Department of Primary Industries

OUT15/22793

Mount Owen Continued Operations Project (SSD 13_5850) Comment on the Response to Submissions Report

Comment by DPI Water

Figure 2E: Conceptual Final Landform

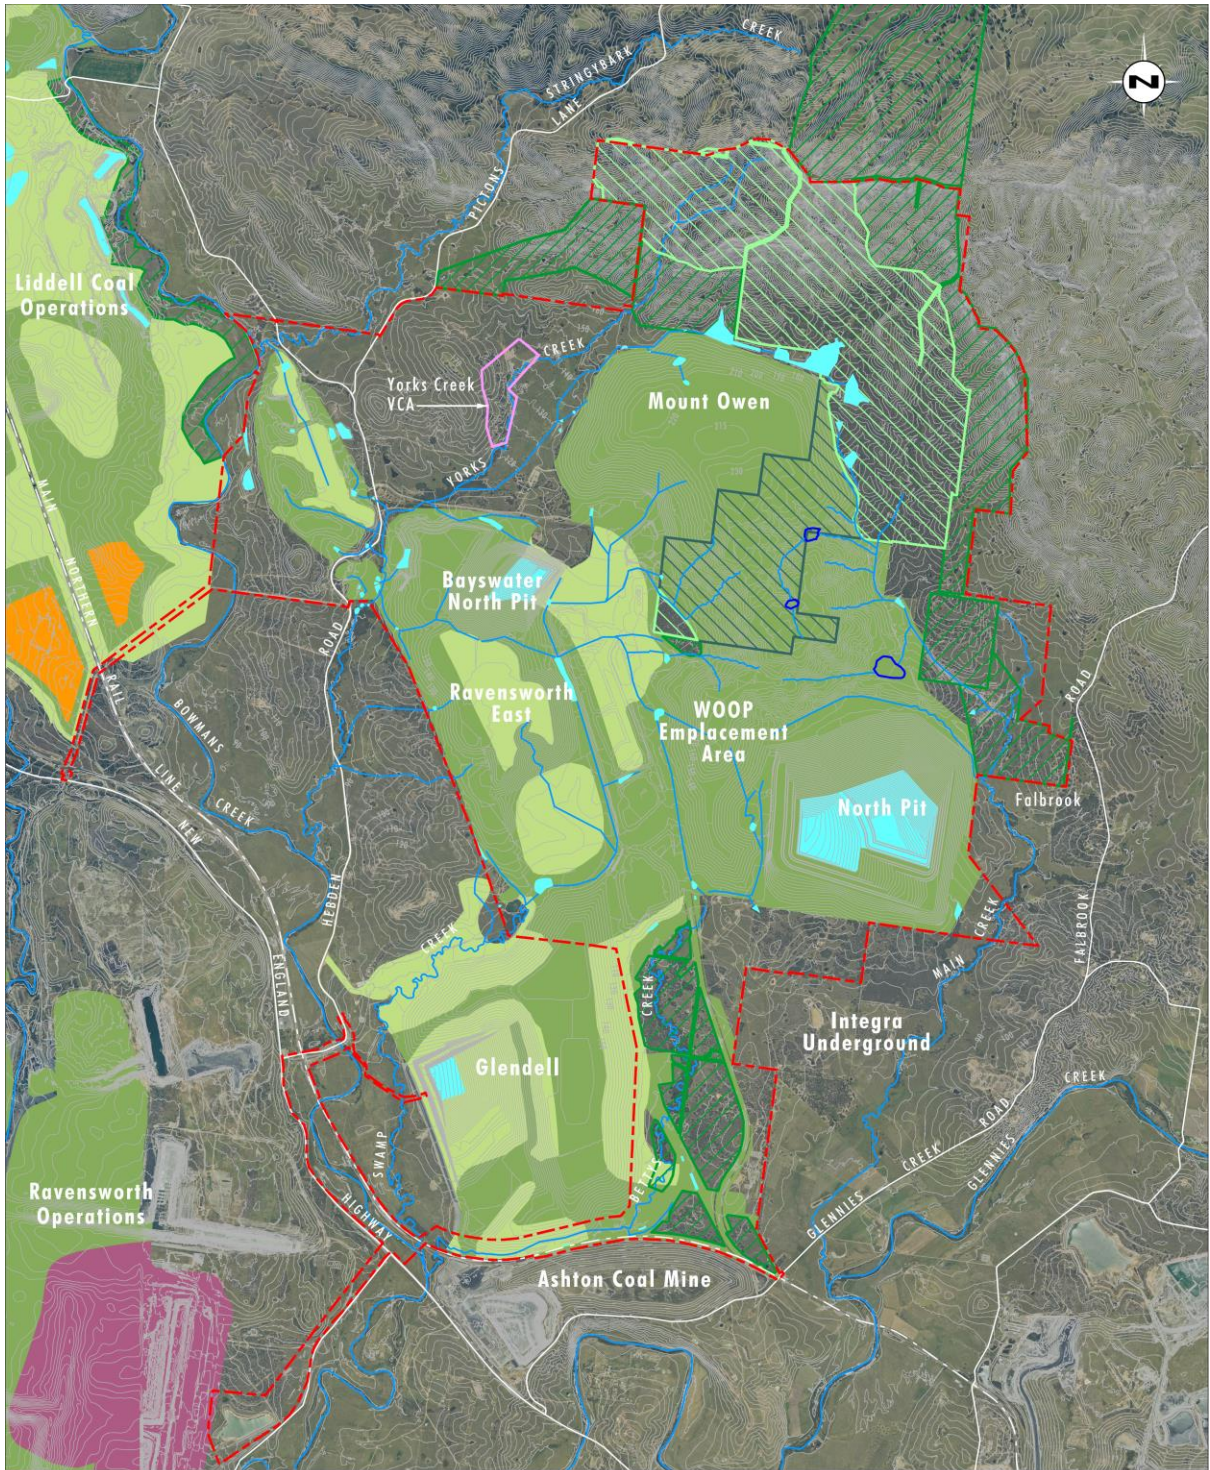
The final landform proposed (Figure 4.5 of Surface Water Assessment, EIS) shows over 50 clean water dams of varying size. Even if all of the current Mount Owen landholdings of 4,913 hectares is maintained in ownership of the proponent, the proposed dams shown in the final landform would far exceed the harvestable right of the property of 344ML (just the Rail Loop Dam – 100ML, ECD2 – 310ML, and CHPP Raw Water Dam – 96ML equates to 506ML in total volume alone). This would result in a significant volume of water held in dams that would require licensing within the Jerry's Water Source, which would exceed the licensed entitlement currently held by Mount Owen.

DPI Water requires further information on this licensing issue, including detailed information on the volume of water held in dams in the proposed final landform, information regarding how Mount Owen proposes to account for this water, or a modified final landform, prior to commencement. Mount Owen should liaise with DPI Water in the development of the Water Management Plan to address these issues.

Consultation with DPI Water is requested on the development of the proposed final landform in regards to the reconstruction and rehabilitation of watercourses. It is expected an extensive understanding of geomorphological and hydrological processes will be required to ensure long term stability and rehabilitation is achieved. Mount Owen must ensure consistency with relevant guidelines, such as *DPI Water Guidelines for Controlled Activities on Waterfront Land*, policies and legislative requirements.
